ARACO CONCRETE

SITE DEVELOPMENT PLAN EL PASO COUNTY, COLORADO

PCD FILE NO. PPR1950

# Site Plan

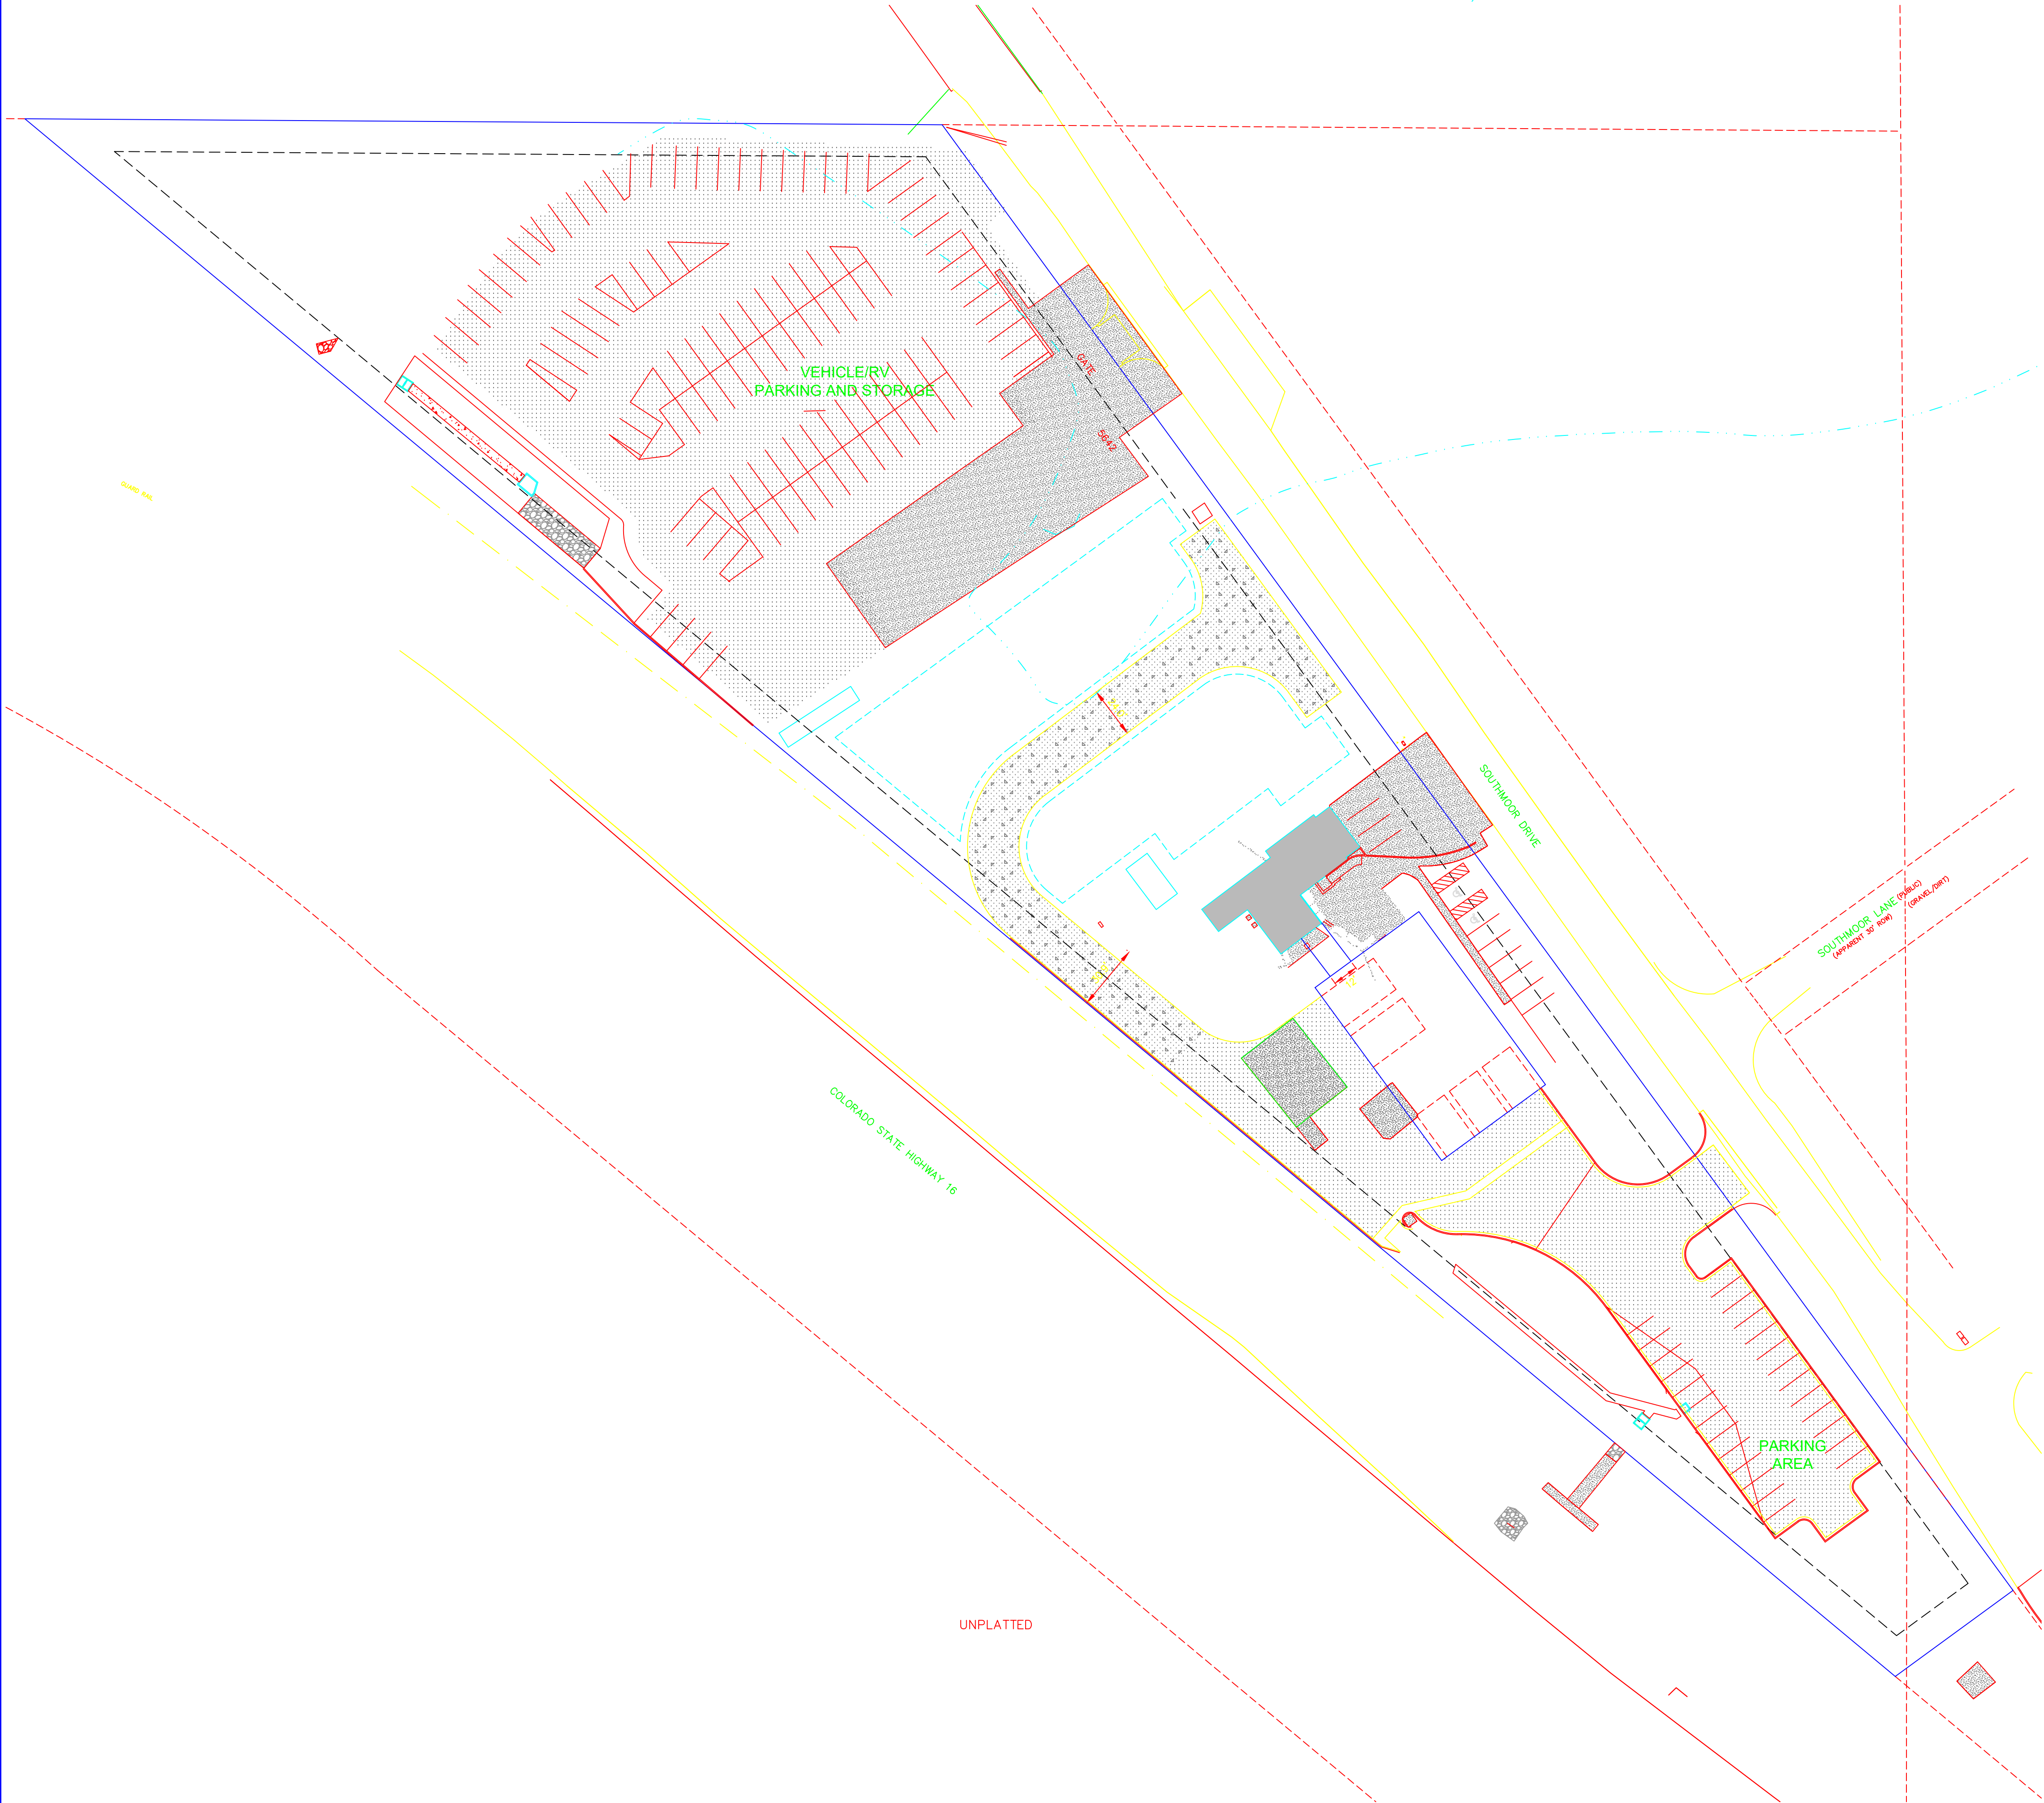
Review 1 comment:
The TIS shall provide recommendation for the gate location. The design of this access must ensure sufficient queuing without blocking the road.
Please incorporate the traffic engineers recommendations into the design of this access.

Review 2: Unresolved. Per the Traffic Study a distance of 65' between the entry gate and Southmoor Drive should be provided. Please incorporate the traffic engineers recommendations and revise the design accordingly.

The traffic study indicates a 24' wide driveway. Note that the minimum per County criteria (ECM 2.4.1.E) is 25'. A deviation request would be required for a smaller width. Be aware that submittal of a deviation request form does not imply that it will be approved by the ECM administrator. Proper justification must be supplied and a decision will be made by the ECM administrator after review of the deviation request.

Please identify the surface material of the storage areas.

Review 1: Note that Southmoor drive is classified as a Collector. Per County criteria access is not permitted. The proposed access points have been discussed with the engineering manager and we have determined that a total of 2 access points will be allowed. Please revise the site plan accordingly. Ensure that the proposed access points meet ECM criteria (see ECM 2.4.1). Coordinate with the traffic engineer.

Review 2: Unresolved. There are still greater than 2 access points shown on the plan (north access, head-in access near the existing/proposed building and south access). As indicated in the review #1 comment, only 2 access points will be allowed. Revise the site plan accordingly.

The location of this access shall meet the criteria in ECM Section 2.4.1.F (Access Clearance from Intersections). Coordinate with your traffic engineer as to where this access should be located to comply with the criteria.

Provide a detail for the trash, where the dumpsters will be stored, how they will be screened and the dimensions of the screening.

Please label this storm facility and indicate it as existing.
